Re: Planning Application Ref 38718/APP/2021/4389- No 11 Thornhill Road

It is noted that following submission of the above planning application, three letters containing comments have been received from occupiers of neighbouring properties. Accordingly, this letter sets out a full written response to all planning issues raised within these comments to assist you in your determination of the application.

Title:
Proposed First Floor Plan

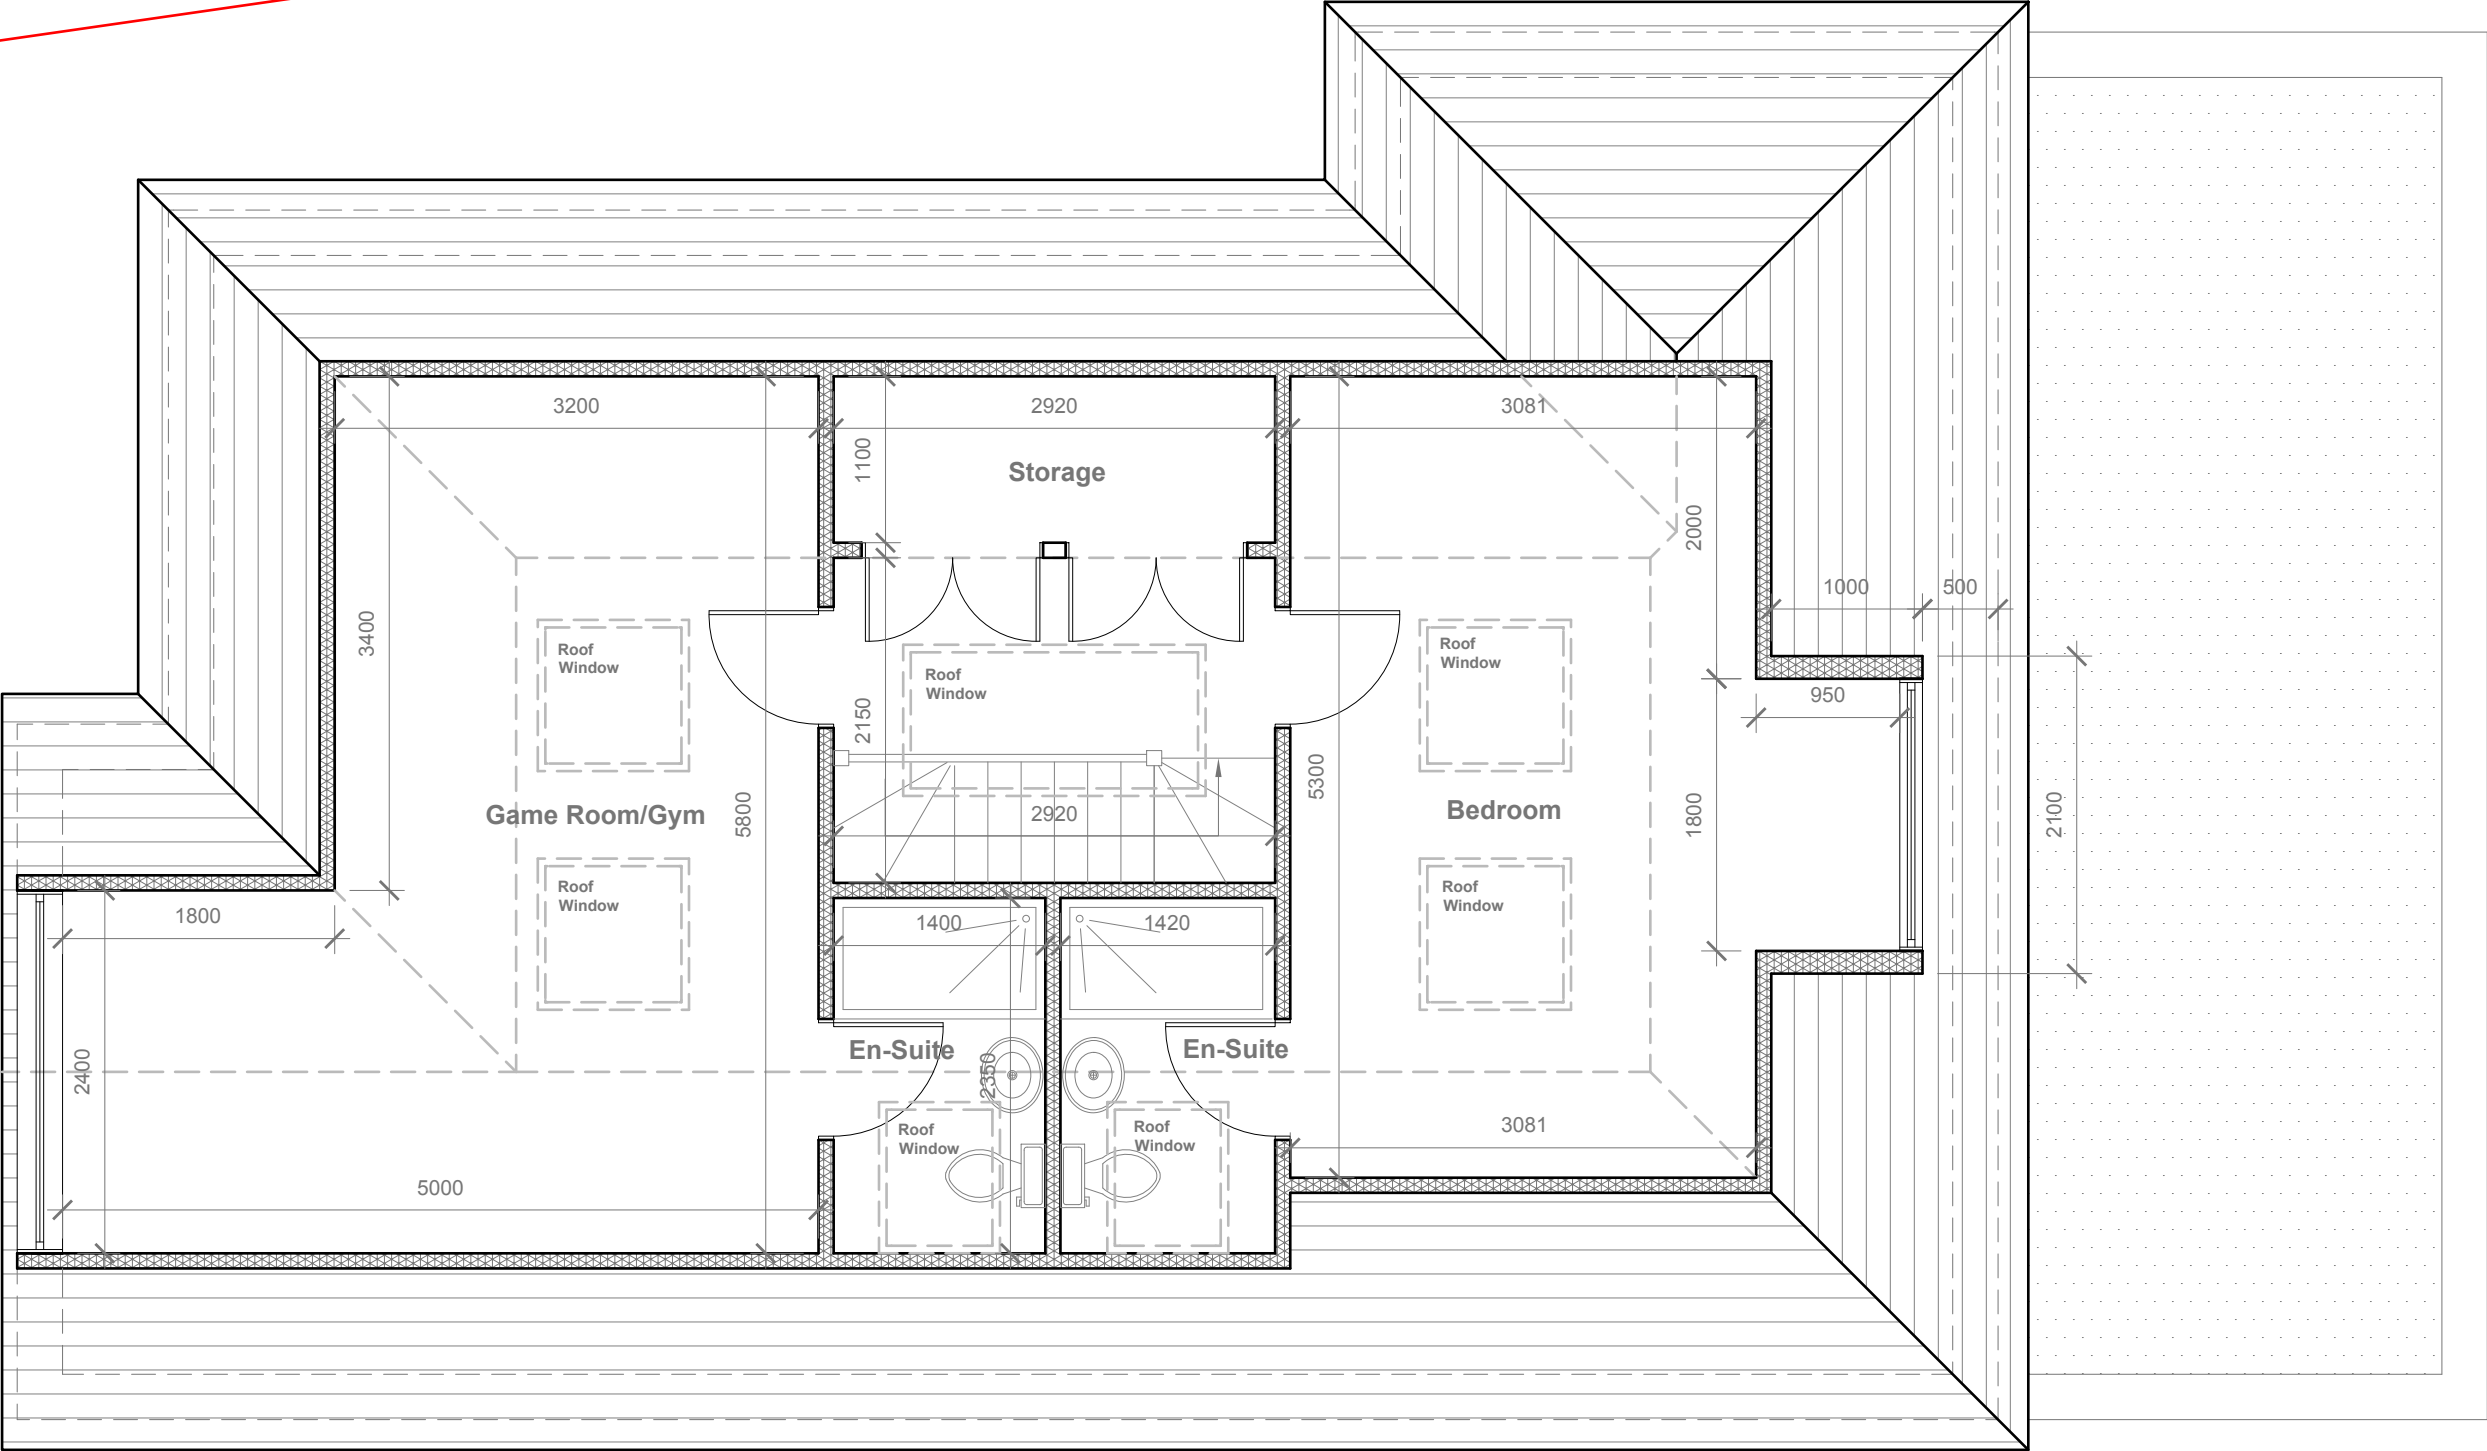
"The proposed plans for No. 11 Thornhill Road show windows to the right hand side of the house on the first floor, which faces Bellamy Close. I object to these plans as this would greatly invade my privacy and those at Nos. 31, 29 and 28. The distance between the rear of my home and the side of No. 11 Thornhill Road, which faces my home, is not much, as such the view from No. 11 into my home will be too close and will be an invasion of privacy for me and my family. Please review these plans with a view to removing those windows that face my home & Bellamy Close."

All windows within the first floor side elevations are high level and serve en-suites. Therefore, these are considered non-habitable rooms and may be secured by condition to be obscure glazed.
